Application No: EP/126/20/HH
Site Address: 56 Angmering Lane East Preston BN16 2TA
Description of works: Resubmission (EP/37/20/HH) of proposed extensive refurbishment of existing 2-storey dwelling to include, single storey side/rear extensions, 2-storey rear extension, roof extension and front double garage

Thank you for your internet representation made on 13th November 2020 which has been recorded as an objection with the comments as follows:

Drawing Title: Proposed 2 Storey Rear Extension, Side Extension and Detached Double Garage
Planning Permission

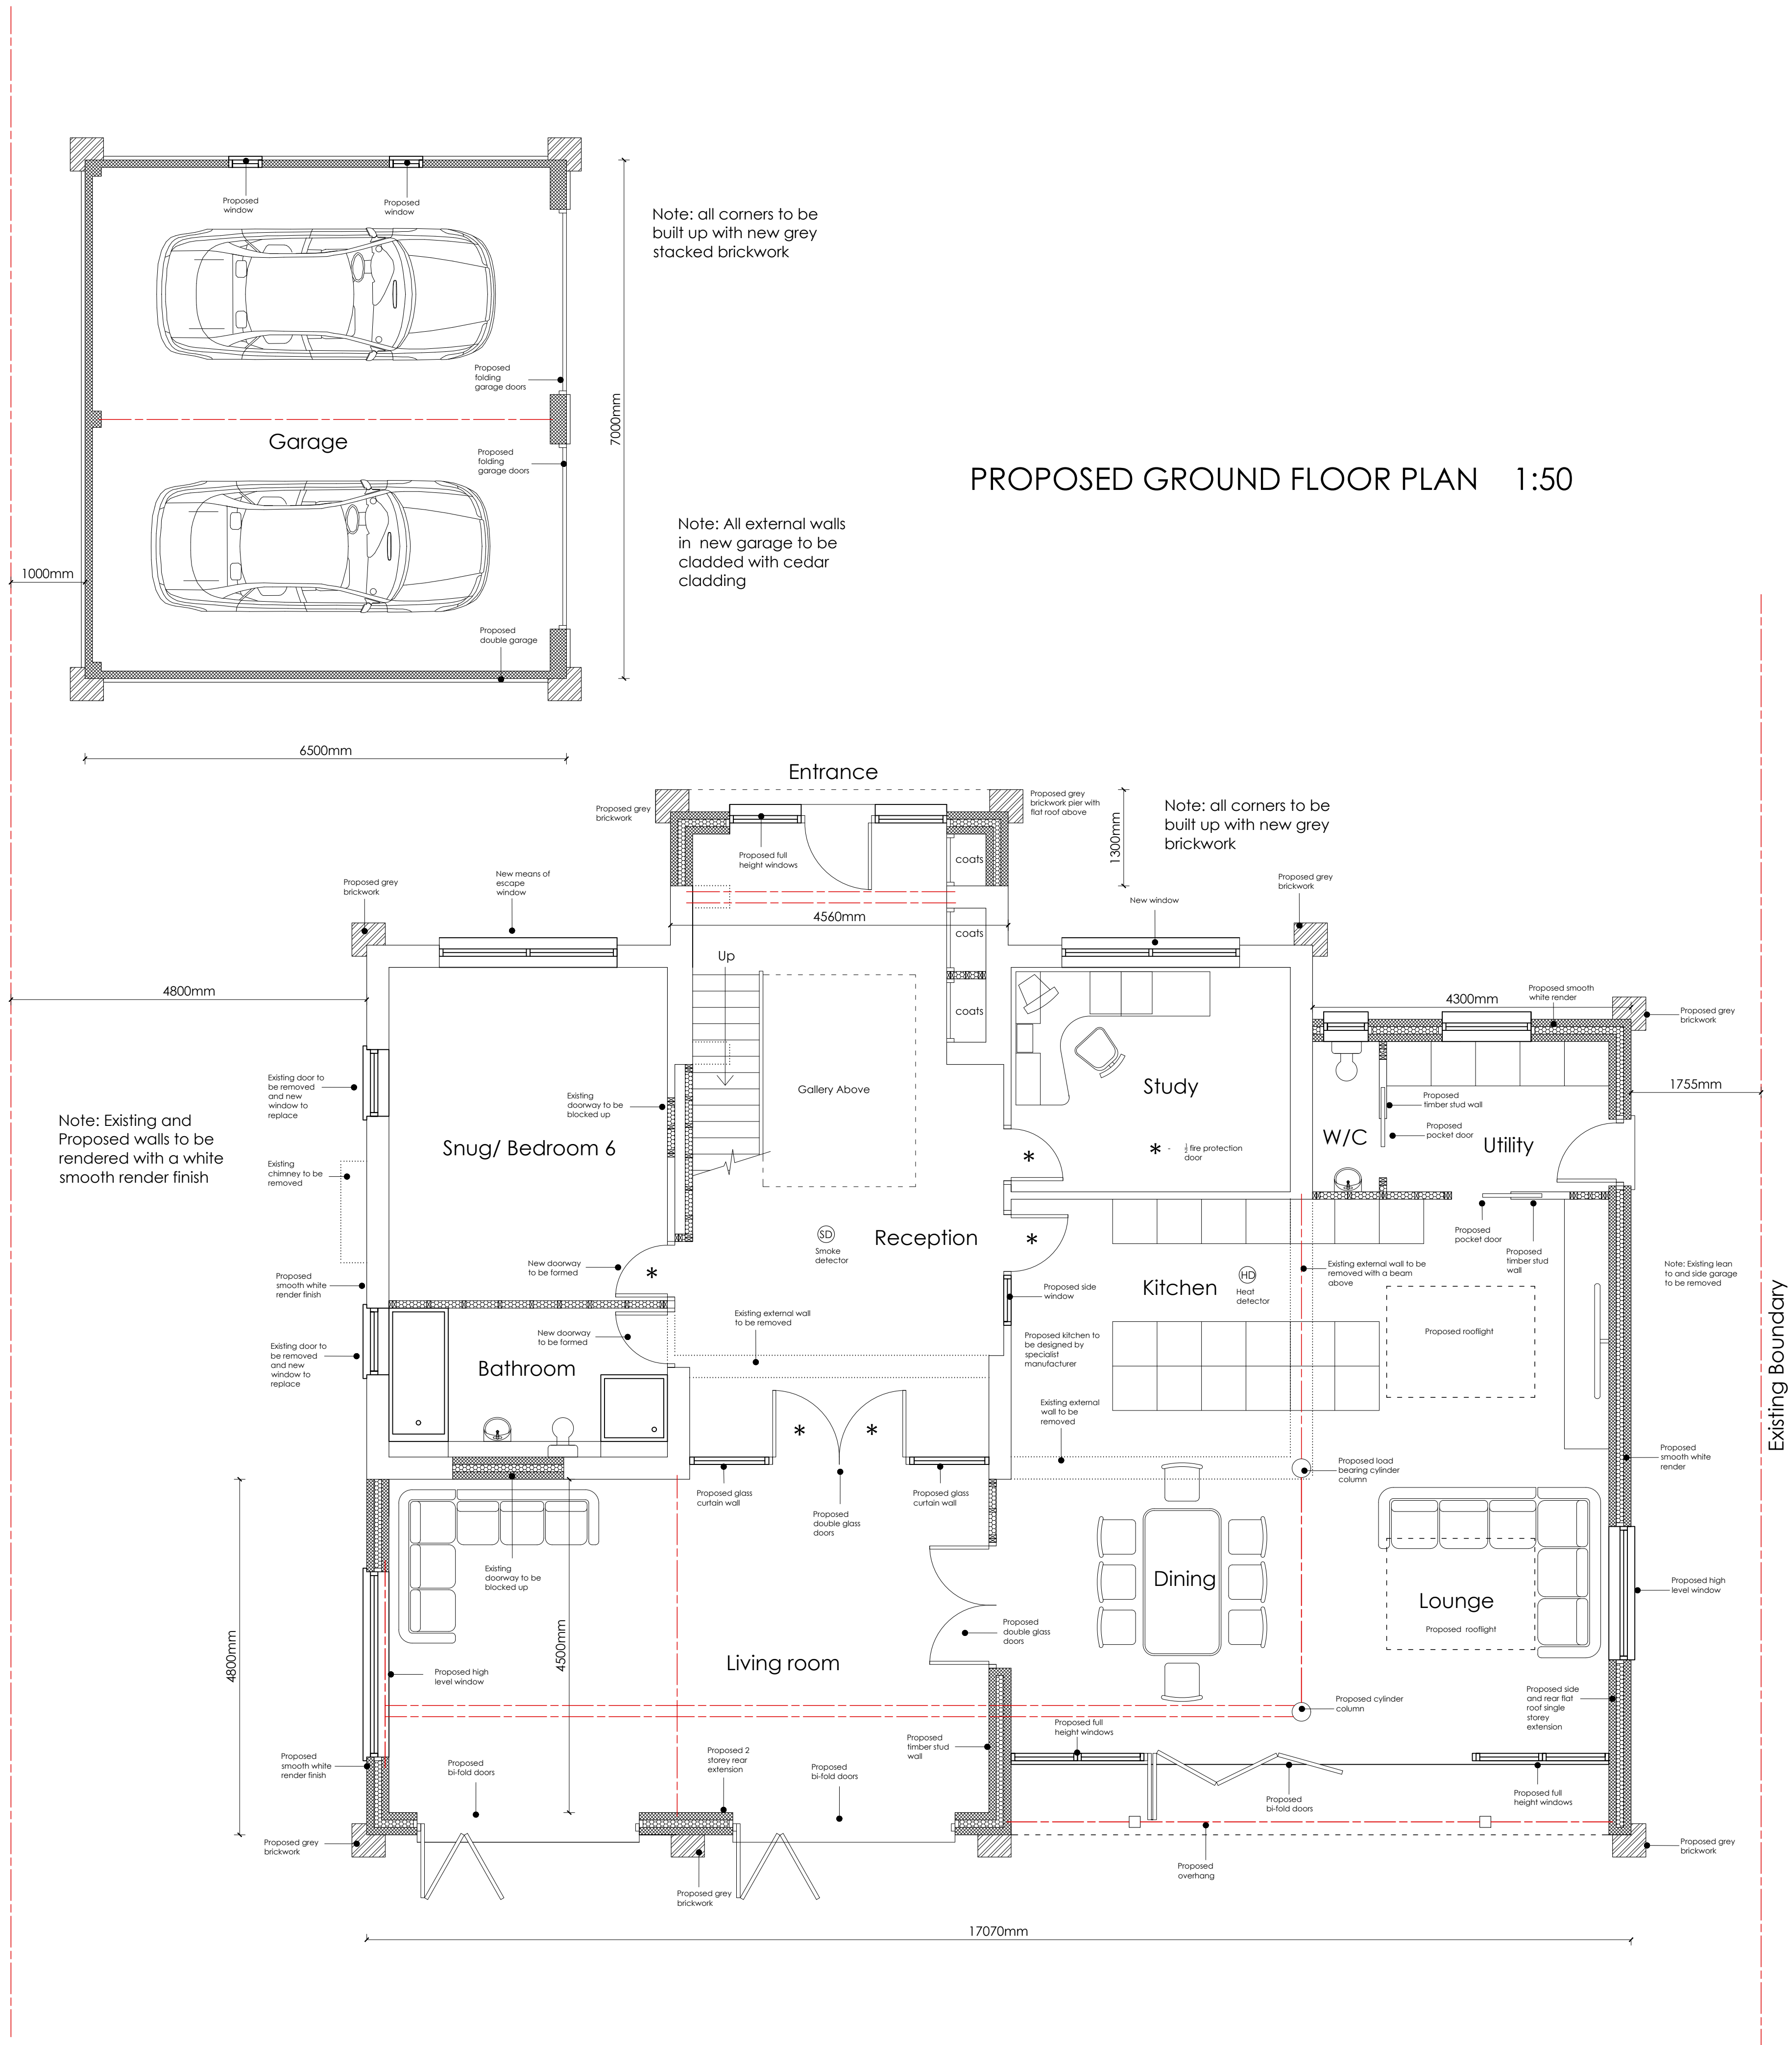
I object to the proposed garage location. I believe it to be bad practice to build in front of windows. The Arun DC design guide is against to protect the light and overshadowing in the property itself and neighbouring properties. Personally I do not want any precedent set.
